# FIVE ESTUARIES OFFSHORE WIND FARM

SCHEDULE OF CHANGES TO THE DRAFT  
DEVELOPMENT CONSENT ORDER  
(TO REVISION F, DEADLINE 5)

Application Reference	N/A
Application Document Number	N/A
Revision	N/A
APFP Regulation:	N/A
Date	January 2025

APFP Regulation: 5(2)(k)
 Sheet No: 11 of 20

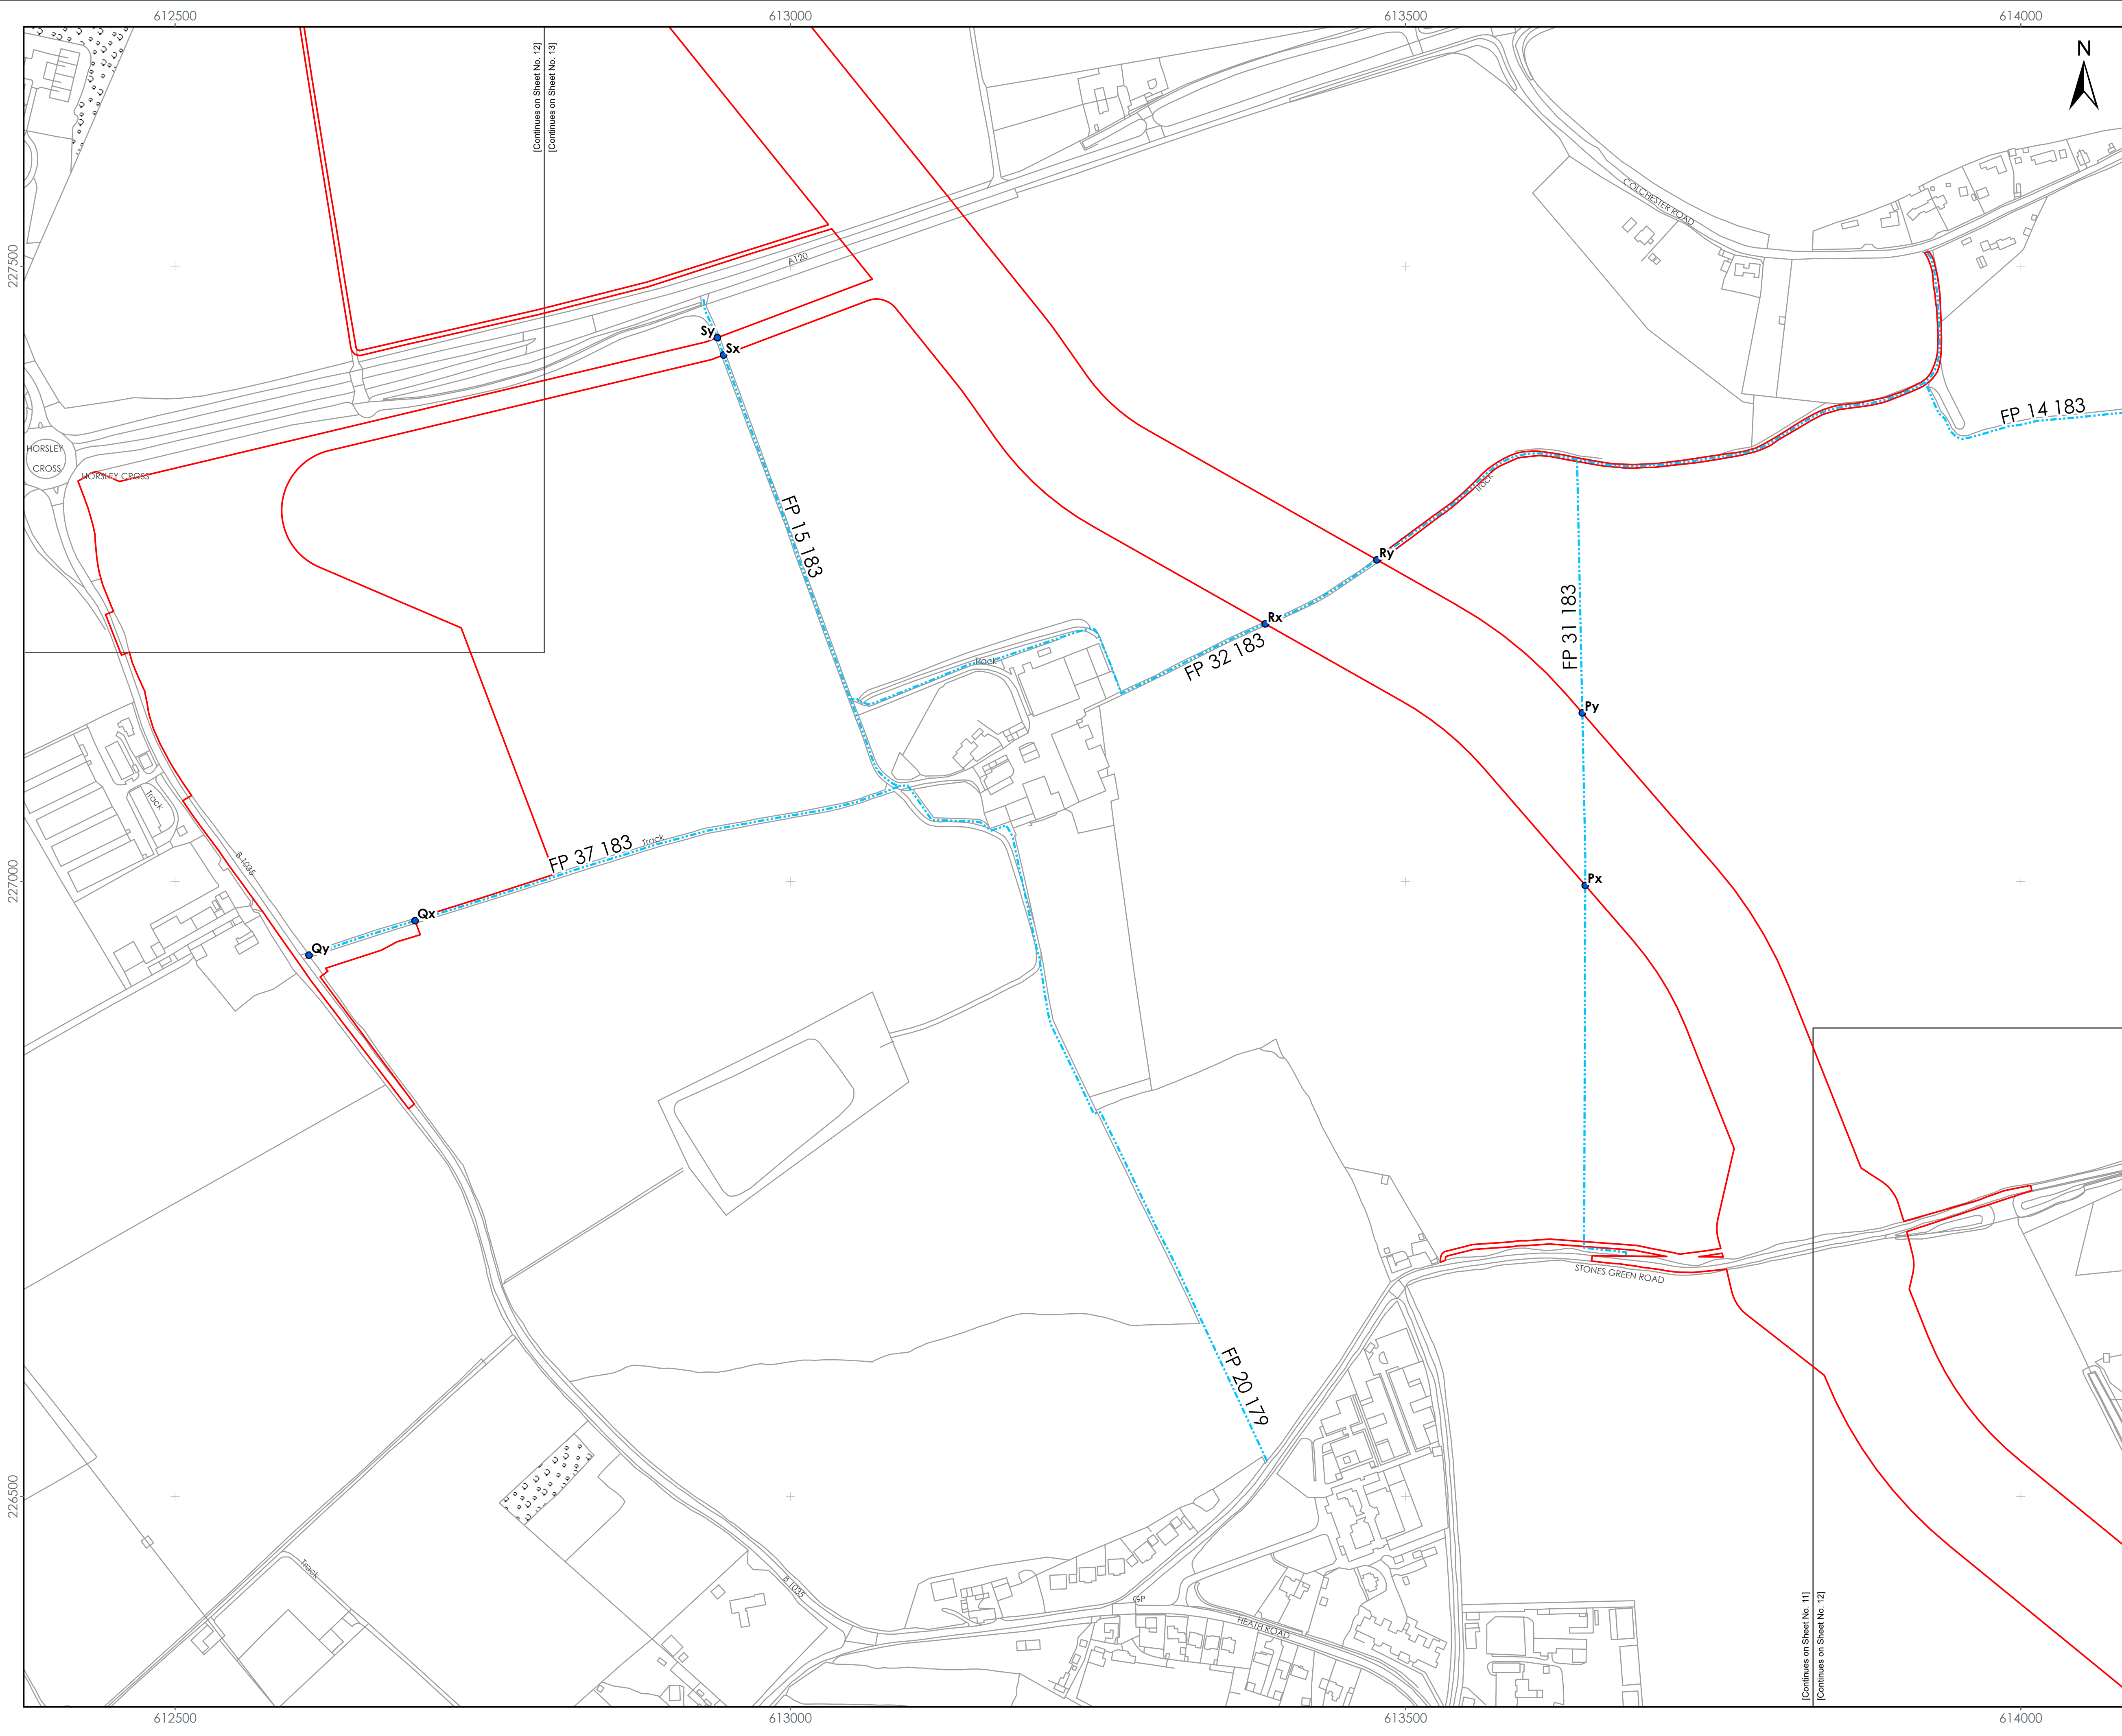
FP8 179	Between points <a href="#">Mw to Mx</a> and <a href="#">My to Mz</a> as shown on sheets 10 and 11 of the temporary closure of public rights of way plan	
	Part 4, Speed limits		To add the additional speed limits forming part of the change request and to correct a typographic error
